The Secretary
 NSW Planning, Industry & Environment

I refer to the Department’s below email of 23 September 2021 regarding the Environmental Impact Statement (EIS) for State Significant Development SSD-10272349 Yiribana Logistics Estate for ‘Concept plan and Stage 1 DA for an industrial estate. Stage 1 comprises two warehouses, site-wide bulk earthworks and retaining walls, an internal road network, storm water works, car parking, signage and landscaping’ located at Mamre Road, Kemps Creek (Lots 59 & 60 DP 259135) in the Penrith City Local Government Area (LGA). Submissions need to be made to the Department by 21 October 2021.

Please refer to Endeavour Energy’s previous submissions made to the Department via email on 25 October 2020 for the Secretary’s Environmental Assessment Requirements (SEARs) for State Significant Development SSD-10272349 for the GPT Industrial Estate. The recommendations and comments provided therein remain valid.

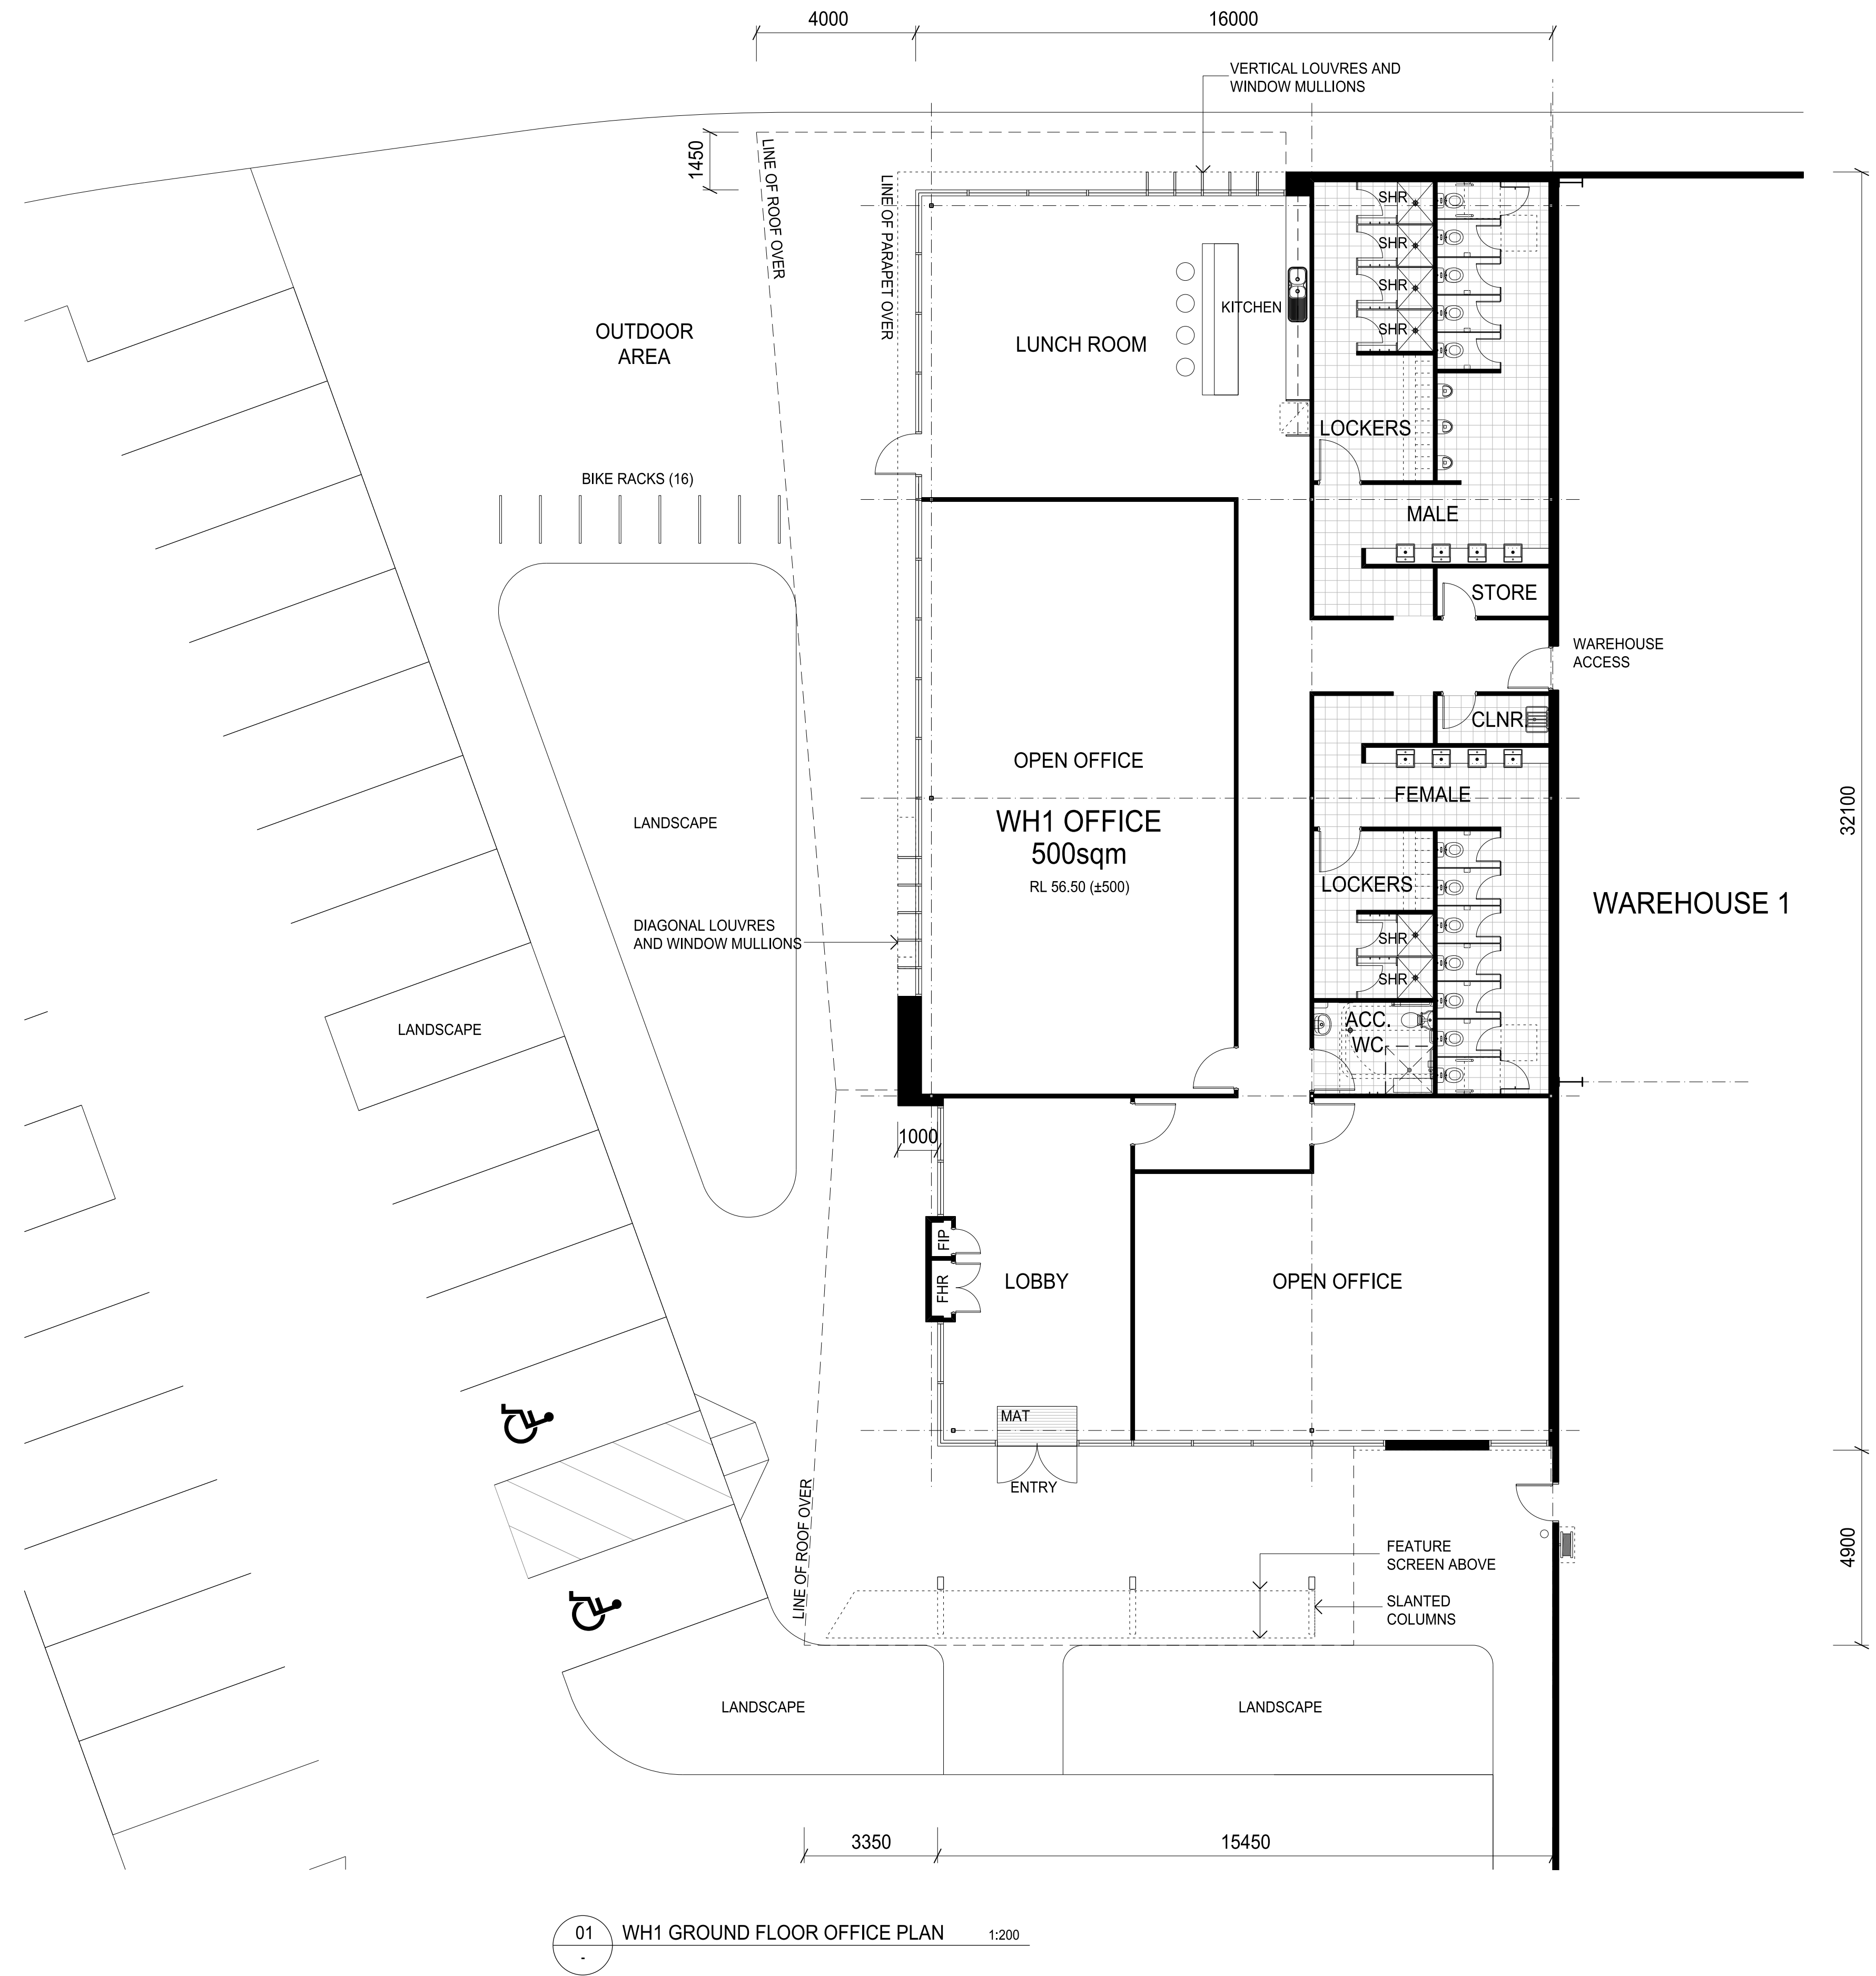
In addition to the advice provided in the Service Infrastructure Assessment, Endeavour Energy has noted as shown in the following extracts of the Site & Warehouse 1 Plan and Site & Warehouse 3 Plan respectively for Stage 1, provision has been made for a padmount substation to both the warehouse sites.

From Endeavour Energy's perspective the fact that provision is being made for the padmount substations is a positive. Endeavour Energy's general requirements is for a padmount substation to be at ground level and have direct access from a public street (unless provided with appropriate easements for the associated underground cables and right of access).

As shown in the following extract of Endeavour Energy's Mains Design Instruction MDI 0044 'Easements and Property Tenure Rights', Figure A4.3 'Padmount easements and clearances', padmount substations require:

- Easement with a minimum size of 2.75 x 5.5 metres (single transformer).
- Restriction for fire rating which usually extends 3 metres horizontally from the base of the substation footing / plinth and 6 metres vertically from the same point.
- Restriction for swimming pools which extends 5 metres from the easement.

The easement should not cross property boundaries but the restriction/s may affect any adjoining property provided they are able to be registered on the title to that property. In addition the following matters also need to be considered in regard to the fire restriction:

- Personnel access doors and fire exit doors to a building are not permitted within the fire restriction area.
- Gas mains/pipes shall not pass through the fire restriction area.
- A 10 metre clearance distance shall be maintained between substation and fire hydrants, booster valves, and the like in accordance with AS2419.1 'Fire hydrant installations System design, installation and commissioning' as updated from time to time.
- Any landscaping that potentially could transfer / provide connectivity for flame or radiant heat from a fire in the substation to a dwelling or building should be avoided.
- The storage of and / or use of flammable, combustible, corrosive or explosive material within the fire restriction should be avoided.

Generally it is the Level 3 Accredited Service Provider's (ASP) responsibility (engaged by the developer) to make sure that the substation location and design complies with Endeavour Energy's standards the suitability of access, safety clearances, fire ratings, flooding etc. As part of the application for connection of load process, the ASP's proposed method of supply will need to be certified by Endeavour Energy's Network Connections Branch.
